**KIRKLEES METROPOLITAN COUNCIL
INVESTMENT & REGENERATION SERVICE**

DELEGATED DECISION TO DETERMINE PLANNING APPLICATIONS

Reference No:	2024/62/92855/W
Site Address:	St Patricks Centre, 2, Trinity Street, Huddersfield, HD1 4DA
Description:	Change of use from mixed use community hall, dance studio and residential flat to place of worship (F1) with associated alterations, refurbishment works and retention of residential flat (C3) (within a Conservation Area)
Recommending Officer:	Katie Chew

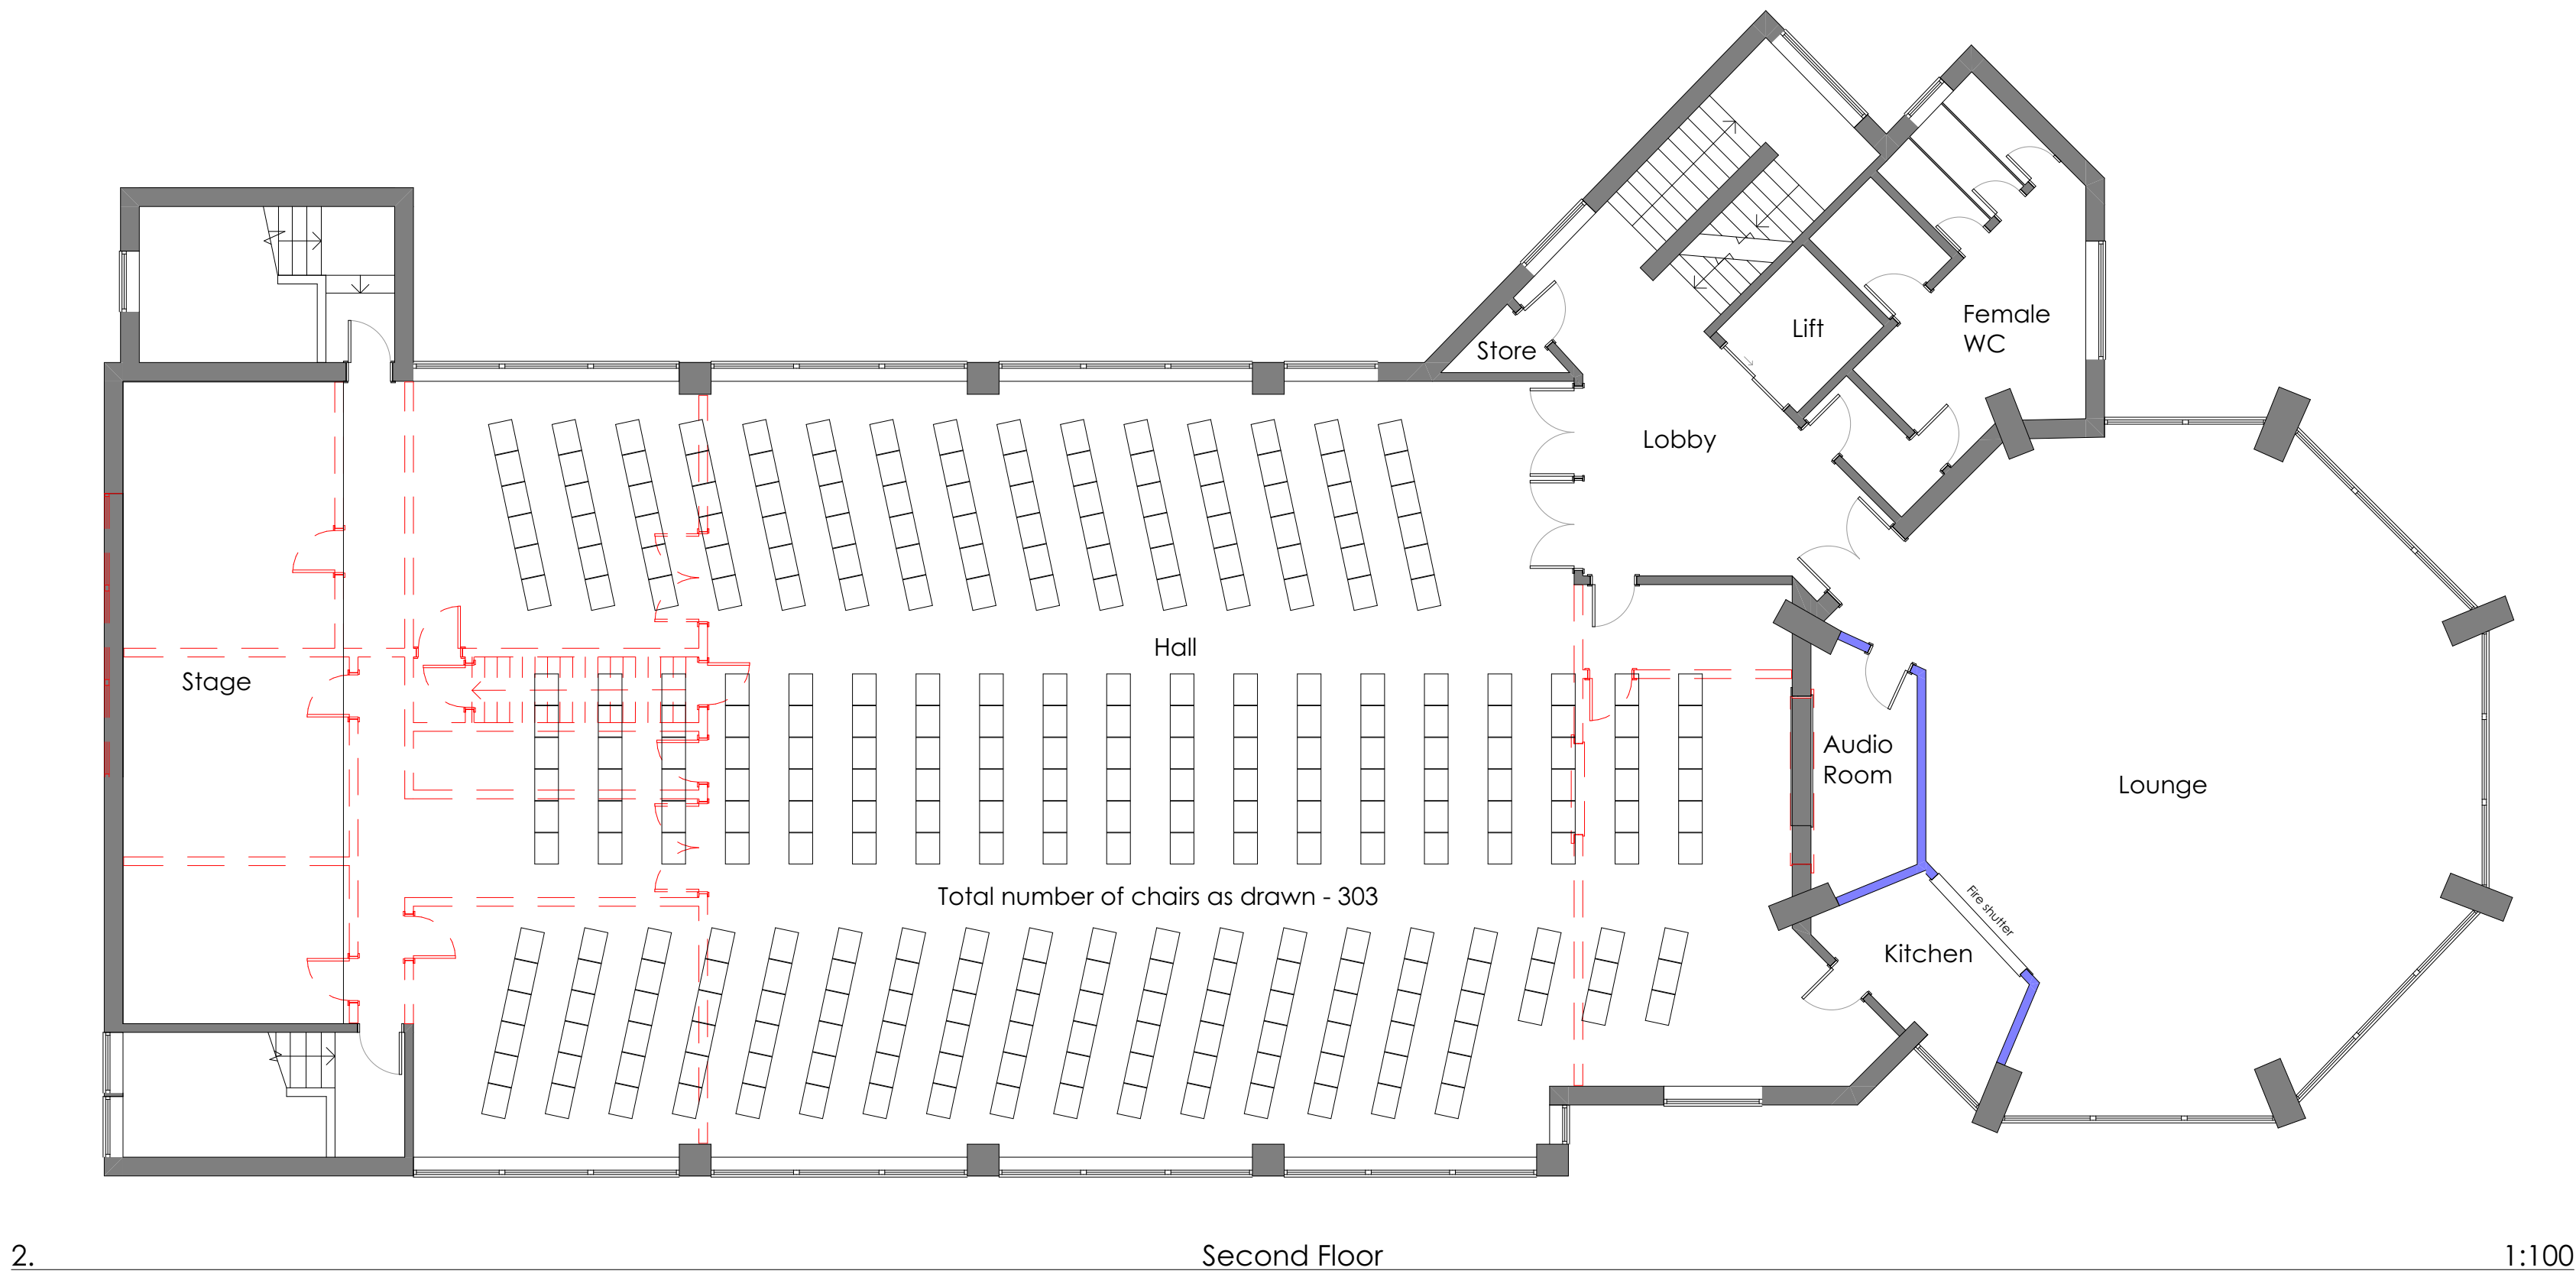
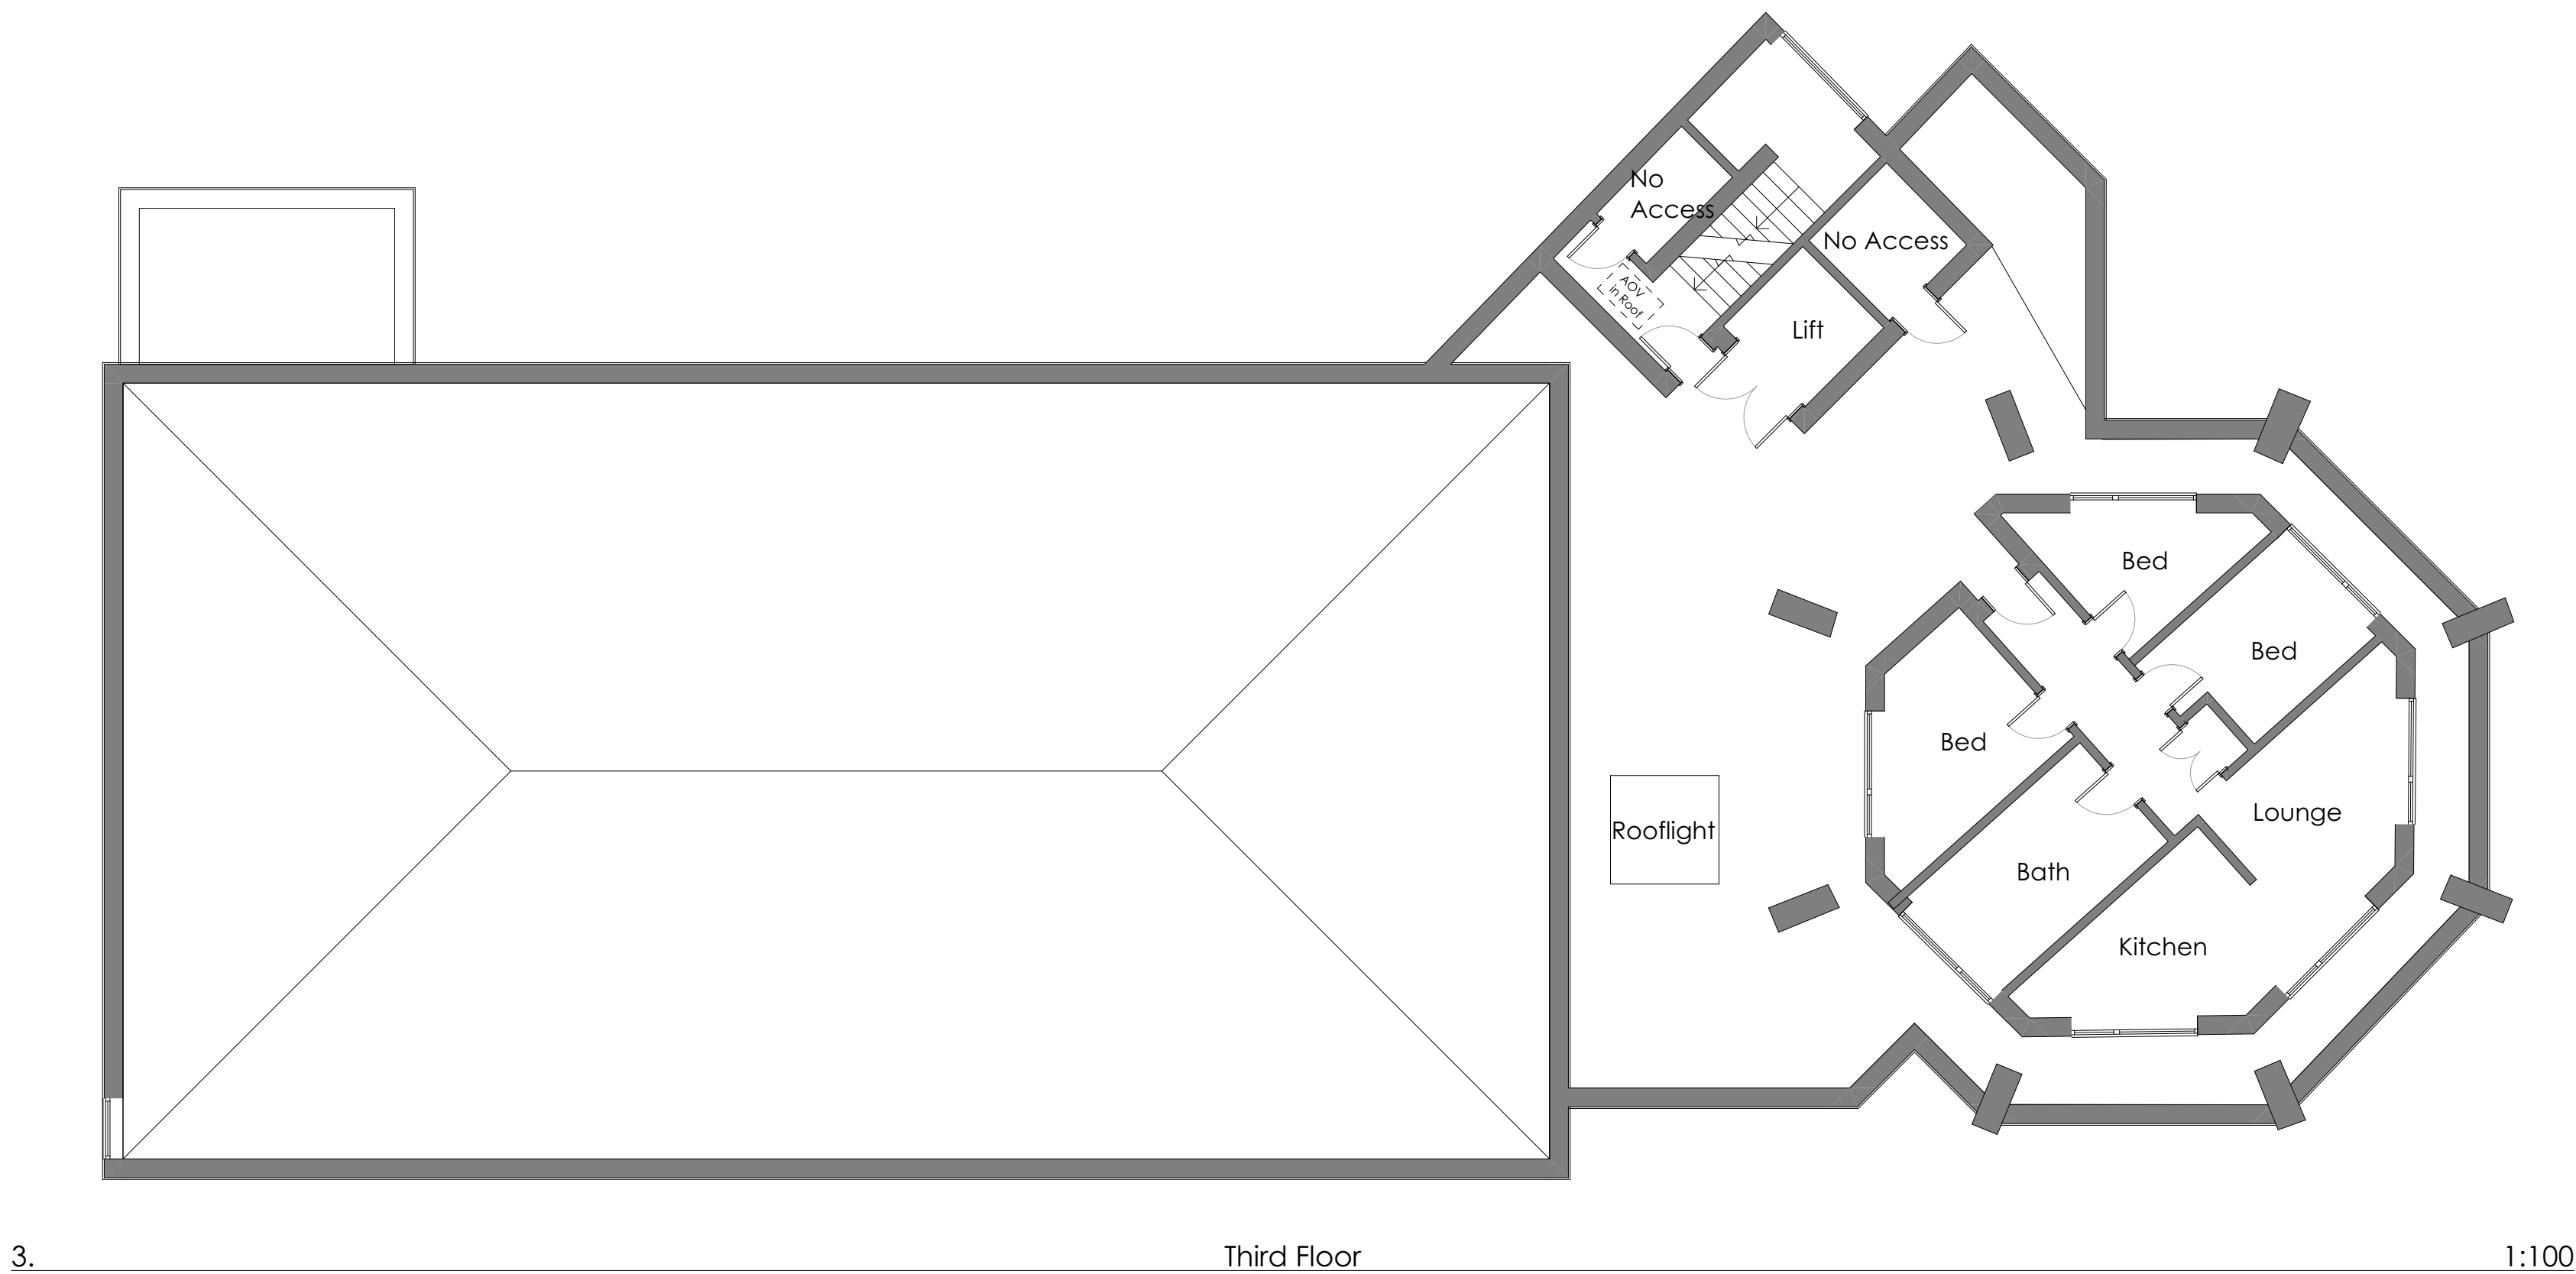
KC Conservation & Design (informal) – Comments received 5th December 2024. No objections subject to the forest green aluminium cladding to the main entrance of the building being replaced with a more neutral colour, in the interests of conserving the character and appearance of the Conservation Area.

Informal consultation has been undertaken with the Council's Conservation & Design Officer who has no objections to the proposals but did request that the forest green aluminium cladding to the main entrance of the building be replaced with a more neutral colour, in the interests of conserving the character and appearance of the Conservation Area. Whilst this is acknowledged, when looking at the immediate area, and context of the site, Officers note that it is not entirely alien in this location to find colours on the brighter side of the spectrum. Directly opposite the host building on Trinity Street, shop fronts comprising of red and green are visible. The proposed location of the cladding is also stepped back and at an angle to Trinity Street and is of a small scale. Furthermore, the applicant has noted that the proposed colour is consistent with the churches overall branding and is included on their website and all of the communication and marketing

information. As a consequence, the Church would like to retain the proposed colour as it is representative of their identity. Officers deem this to be acceptable, subject to a condition which restricts the colour to a Forest Green colour finish to match either RAL 6037 or RAL 6038. This is considered sufficient to preserve and enhance the setting of the Conservation Area.

4. Aluminium cladding hereby approved on the external walls to the Trinity Street entrance, identified as 'Q' on drawing nos. 03_01 R04 'Proposed Elevations', and 03_02 R01 'Proposed Elevations SHT 02', shall be of a Forest Green colour finish to match either RAL 6037 or RAL 6038. The colour finish of this cladding shall be thereafter retained.
